Application for a non-material amendment following a grant of planning permission.

Number	
Suffix	
Property name	Littlehampton Skate Park
Address line 1	Sea Road
Address line 2	
Address line 3	
Town/city	Littlehampton
Postcode	BN16 2NA
Description of site location must be completed if postcode is not known:	
Easting (x)	503972
Northing (y)	101375
Description

Application under Regulation 3 of the Town & Country Planning (General Regulations) 1992 for new concrete skate park with 4 No. floodlighting & new parkour training facility. This application is a Departure from the Development Plan.

Reference number: LU/136/19/PL

Drawing Number:
NSP119 - Arun District Council R3

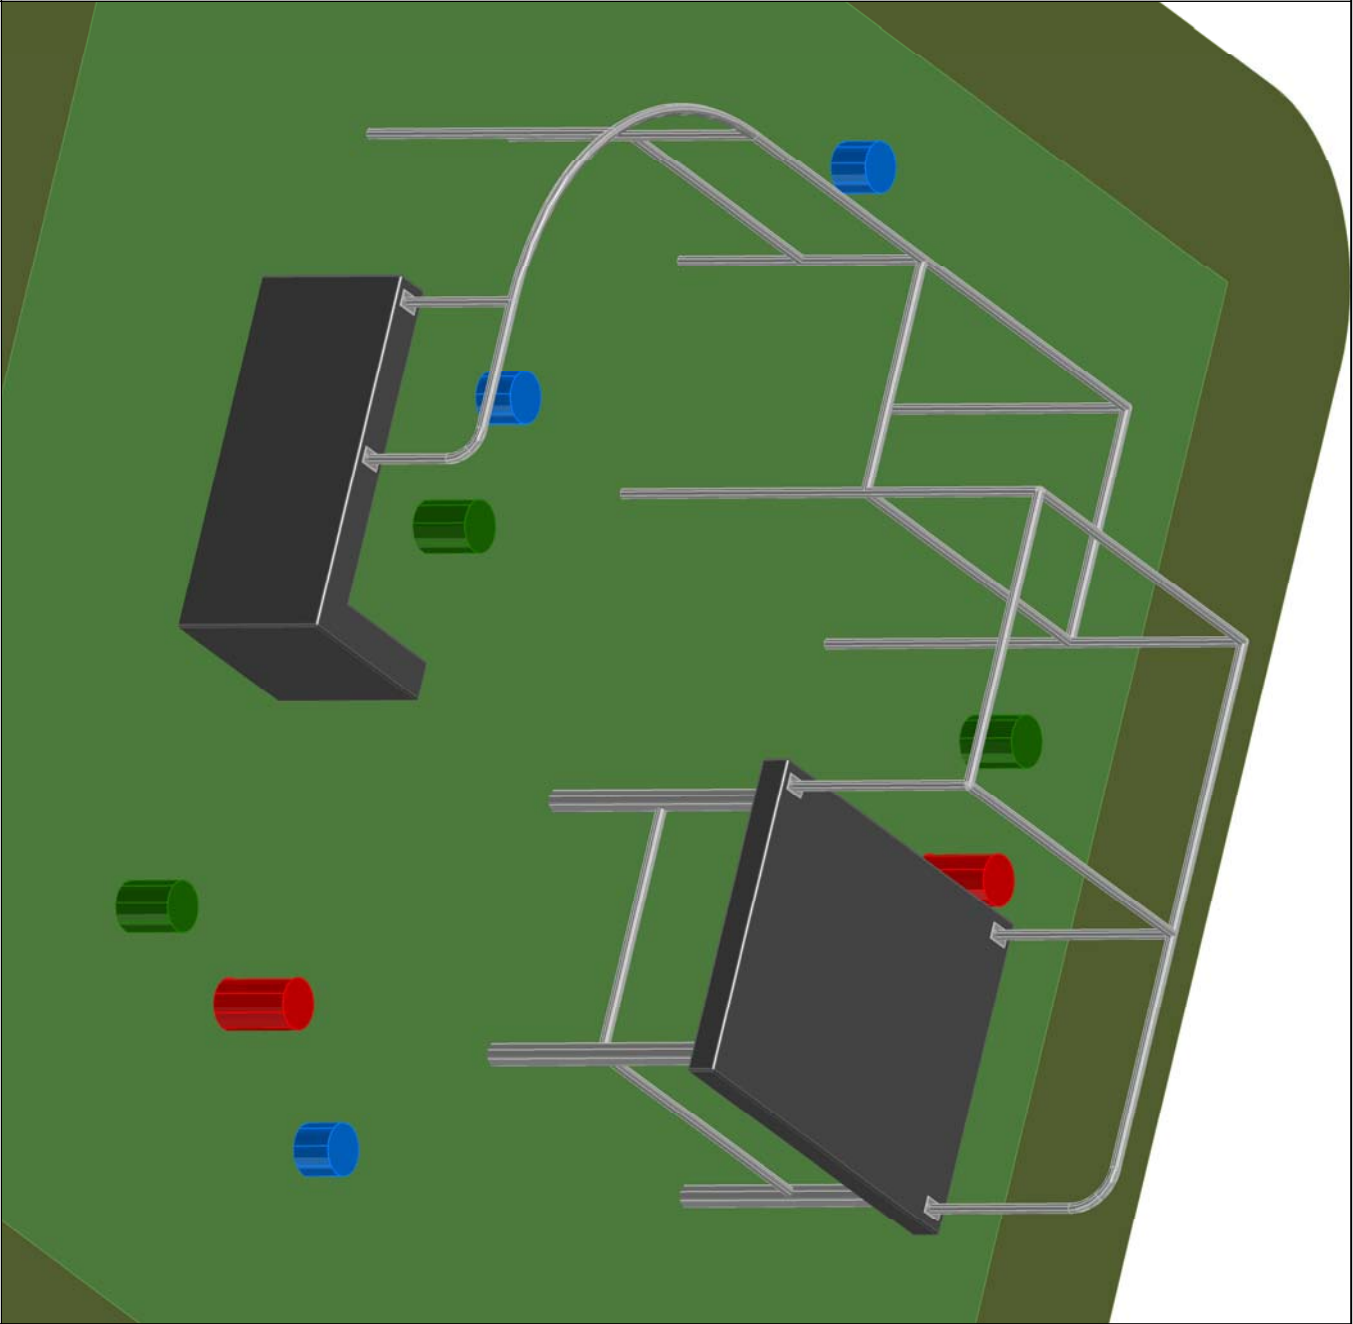
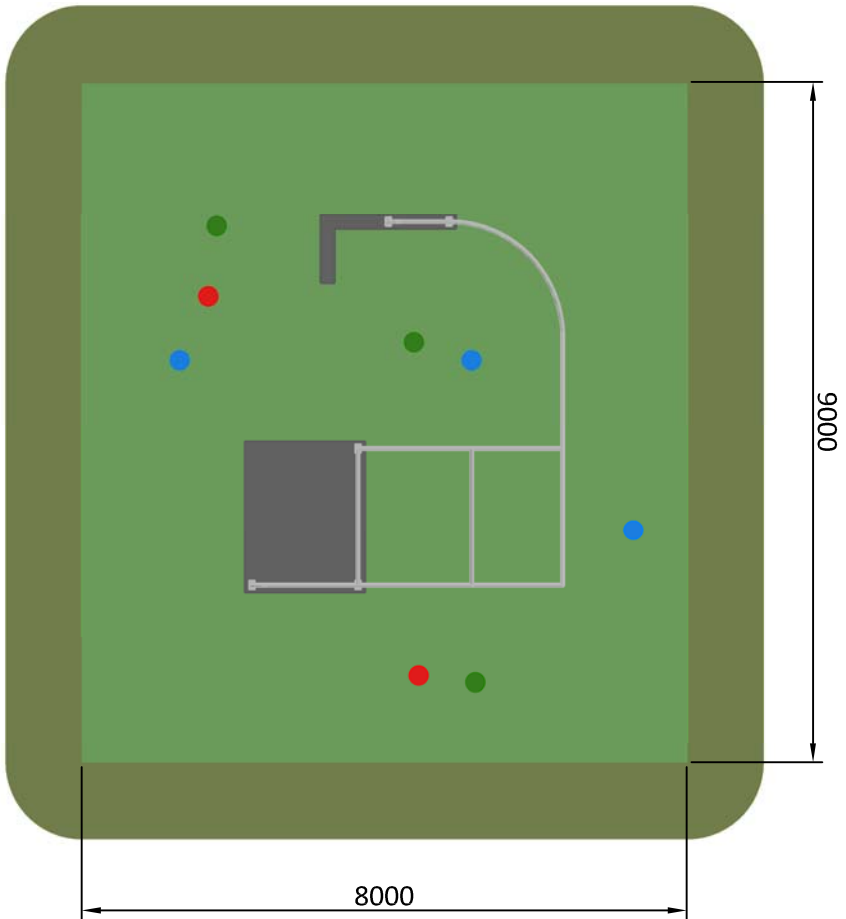
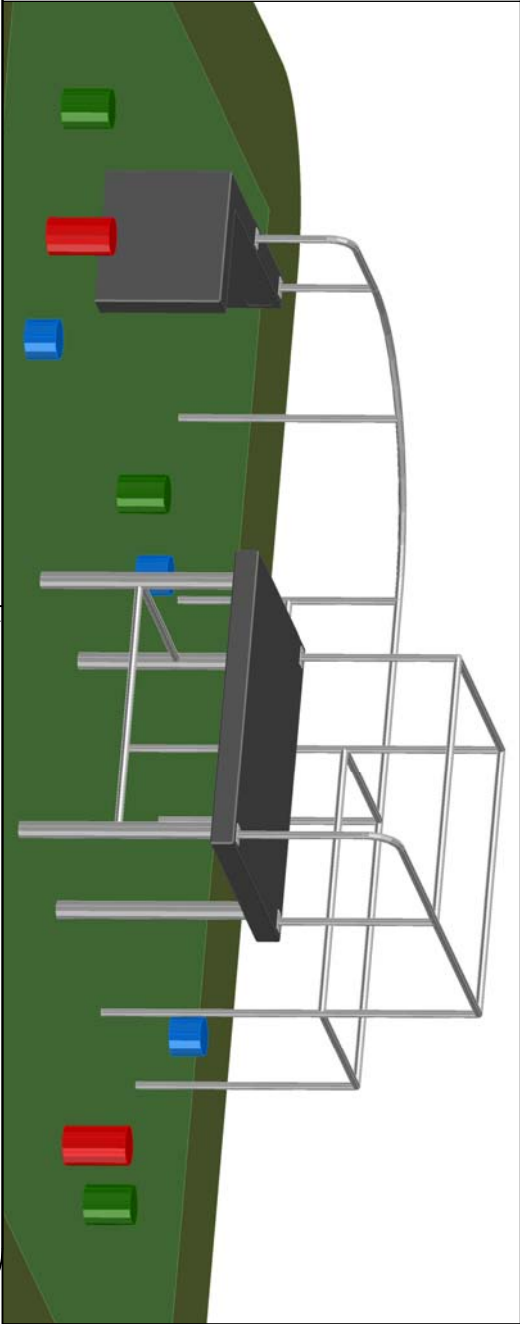
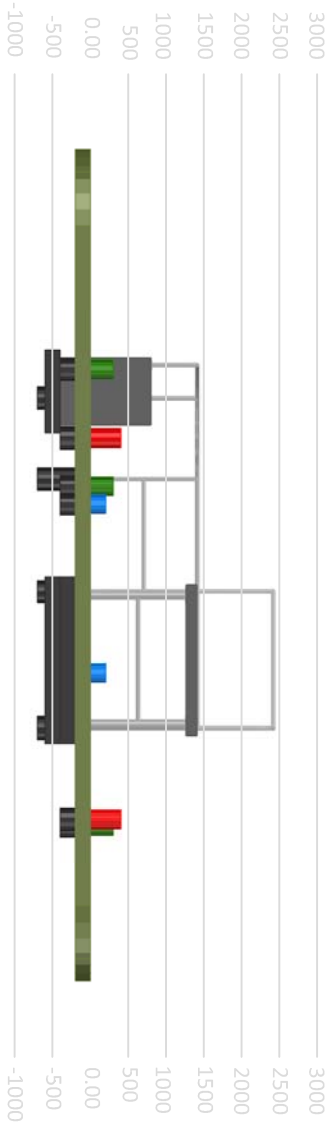
Revision to the design of the parkour training facility.

Amendment to the design to provide a better facility with a greater range of features.

Parkour Training Facility NSP119 - R3
